Our ref: RA/2017/137418/01-L01
Your ref: 2017/92997
Date: 20 September 2017

ERECTION OF 70 (OVER 55) RETIREMENT APARTMENTS COMPRISING OF FOUR BLOCKS, PROVISION OF A COMMUNITY BUILDING, ELECTRICITY SUBSTATION AND LAYING OUT OF INTERNAL ROADS, PARKING AREAS AND GREENSPACE AND ASSOCIATED INFRASTRUCTURE. LIDL, STATION ROAD, MIRFIELD, WF14 8LL

Environment Agency position – Flood Risk Assessment

DRAWING:
APARTMENT BLOCK A
FLOOR PLANS

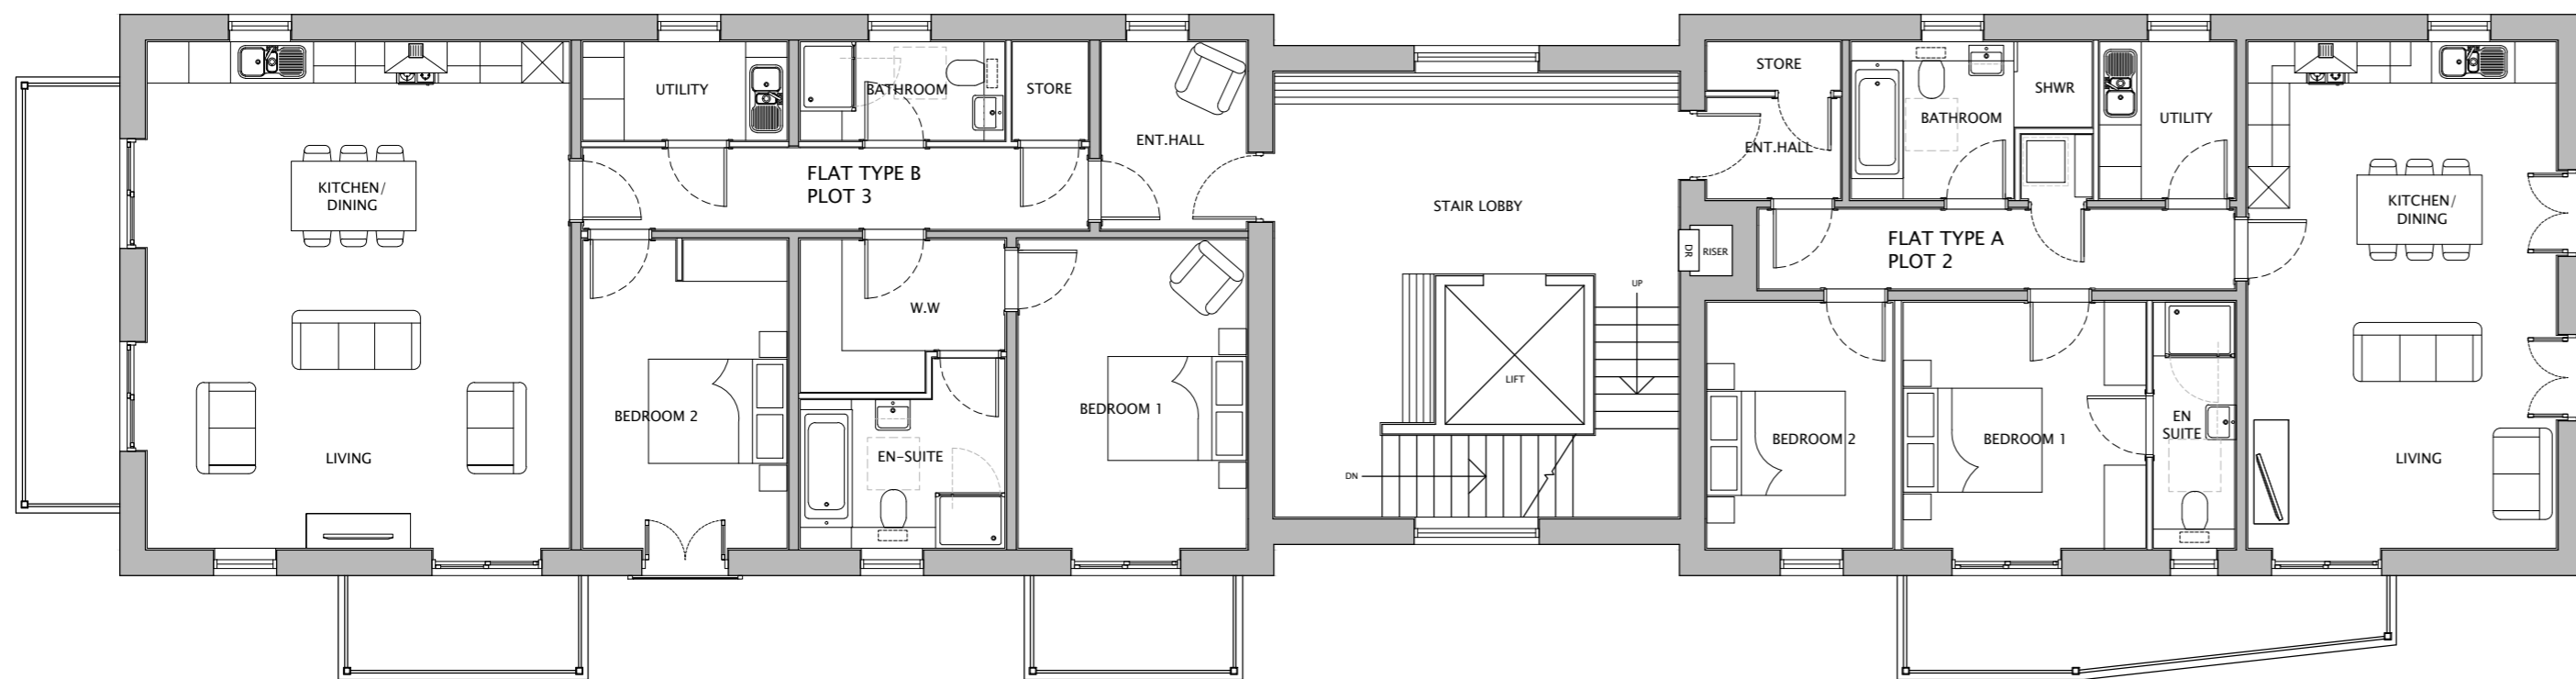
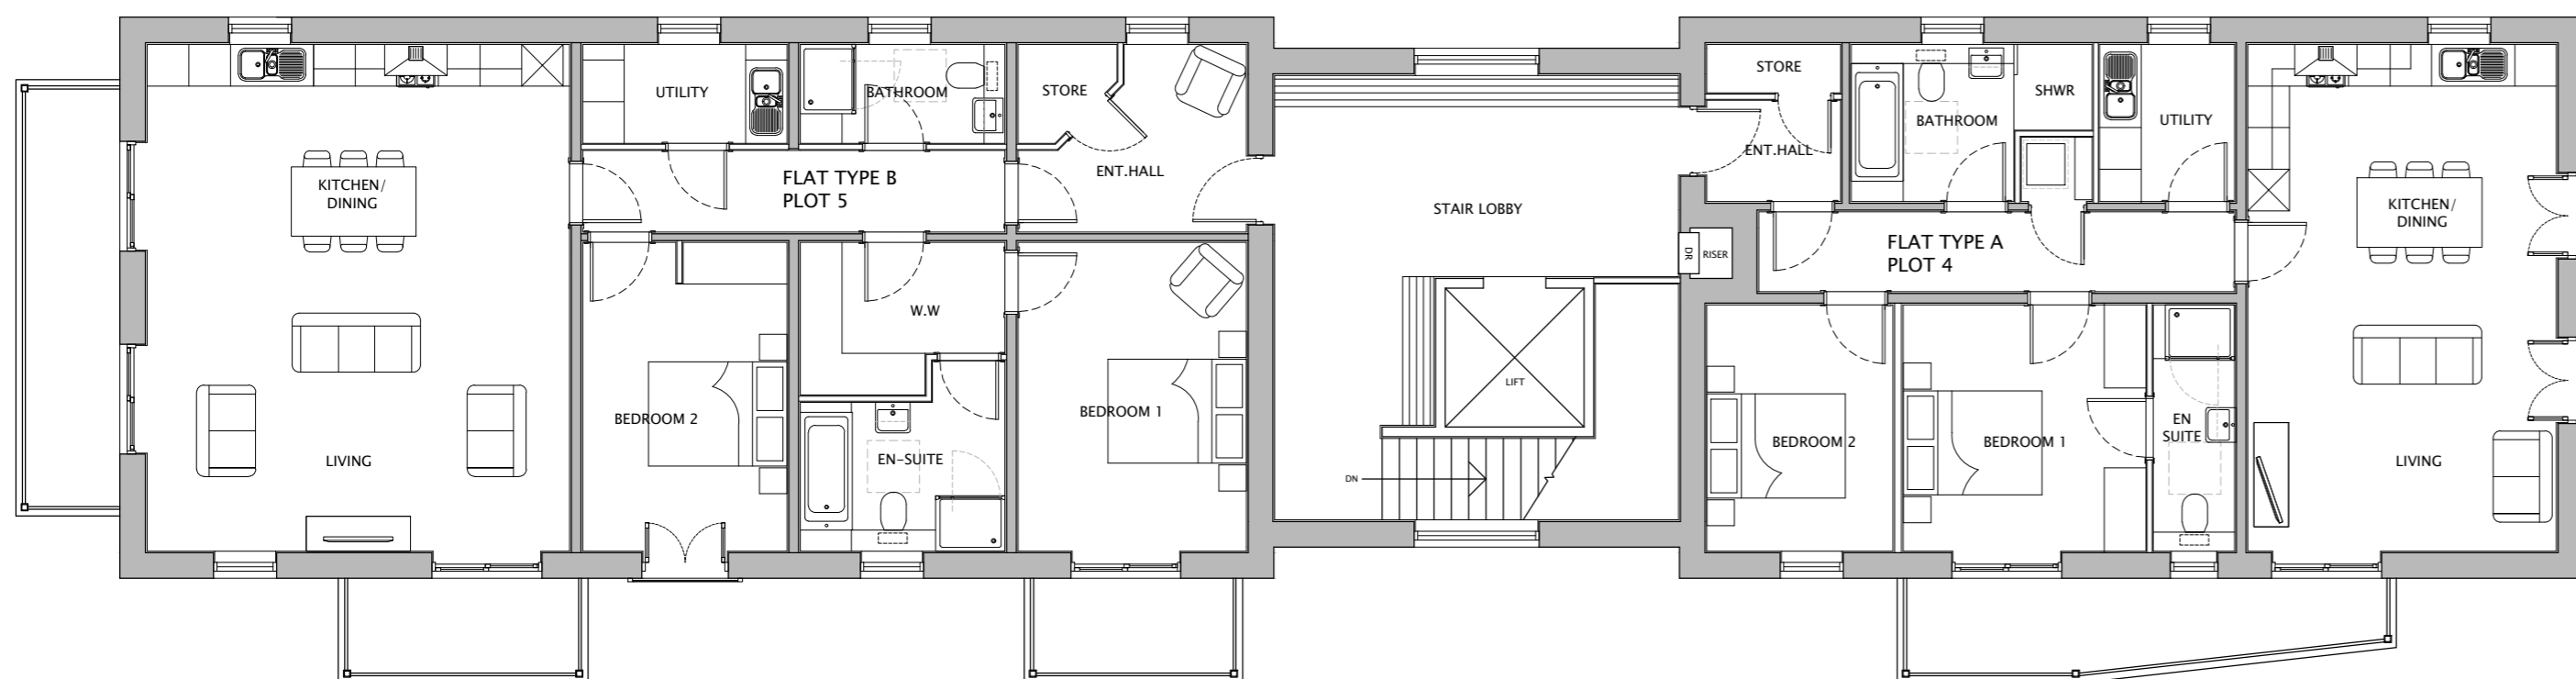
- There shall be no residential areas on the ground floor.
